CITY OF ALBUQUERQUE

**RE: Coors Pavilion Subdivision Lots 2 & 3
9154 Coors Blvd
Grading Plan
Engineer's Stamp Date: 3/1/2017
Hydrology File: G11D069A**

Based upon the information provided in your submittal received 3/24/17, the Grading Plan is approved for Site Development for Building Permit.

CONCEPTUAL GRADING AND DRAINAGE PLAN

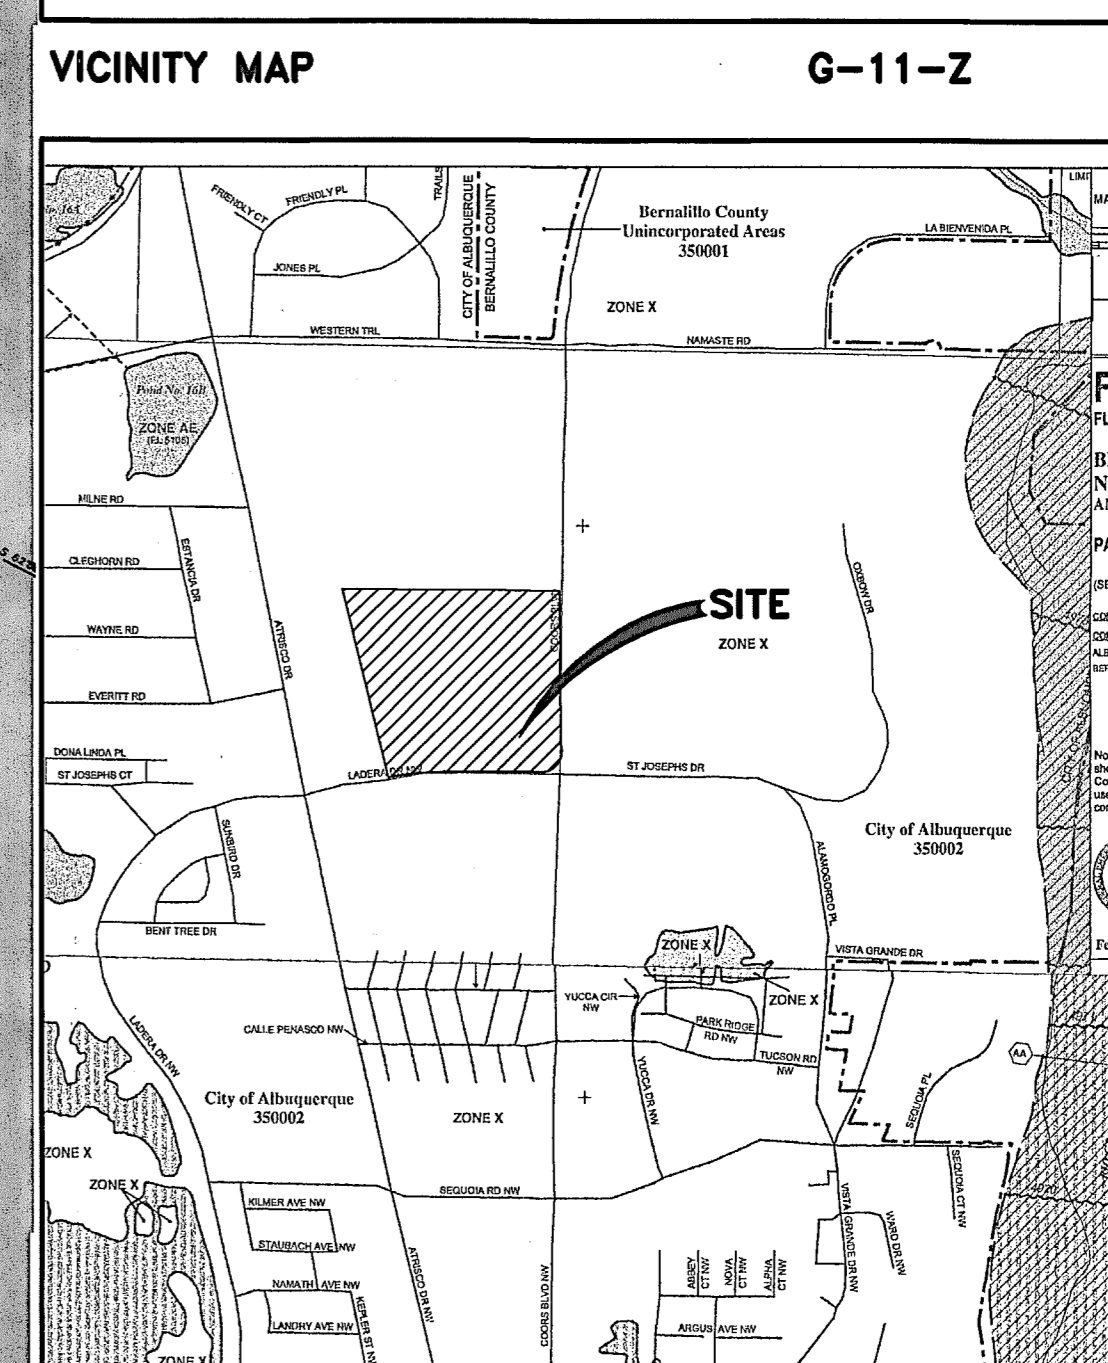
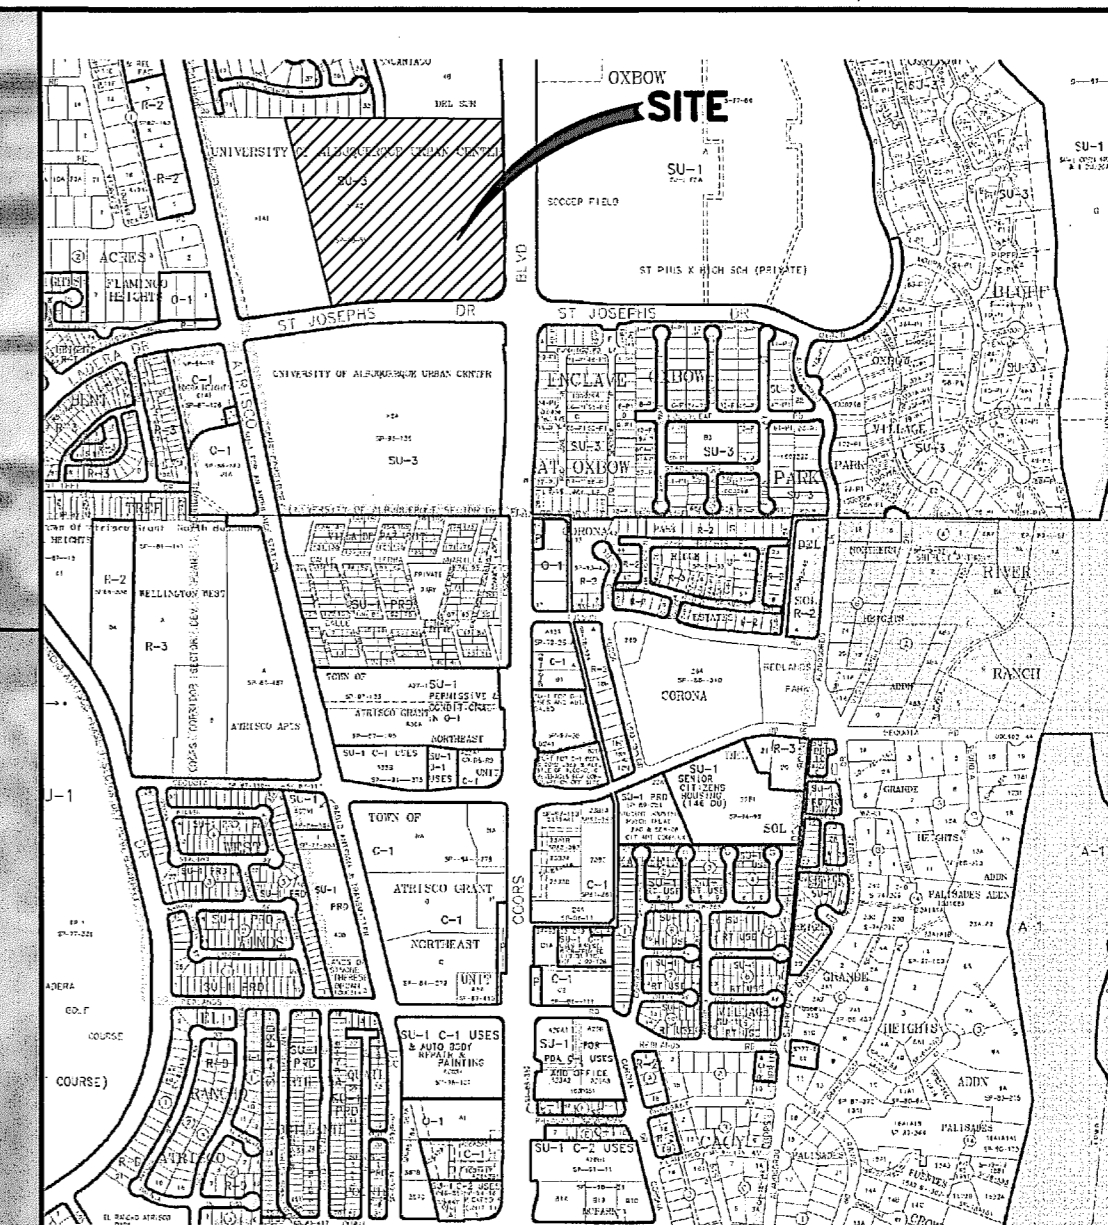
1. Prior to Final Plat, a cross-lot drainage easement will be required for Lot 2 for the benefit of Lot 3.
2. Are either of these buildings restaurants? If so, provide trash enclosure containment and drainage through a grease trap and into the sanitary sewer.
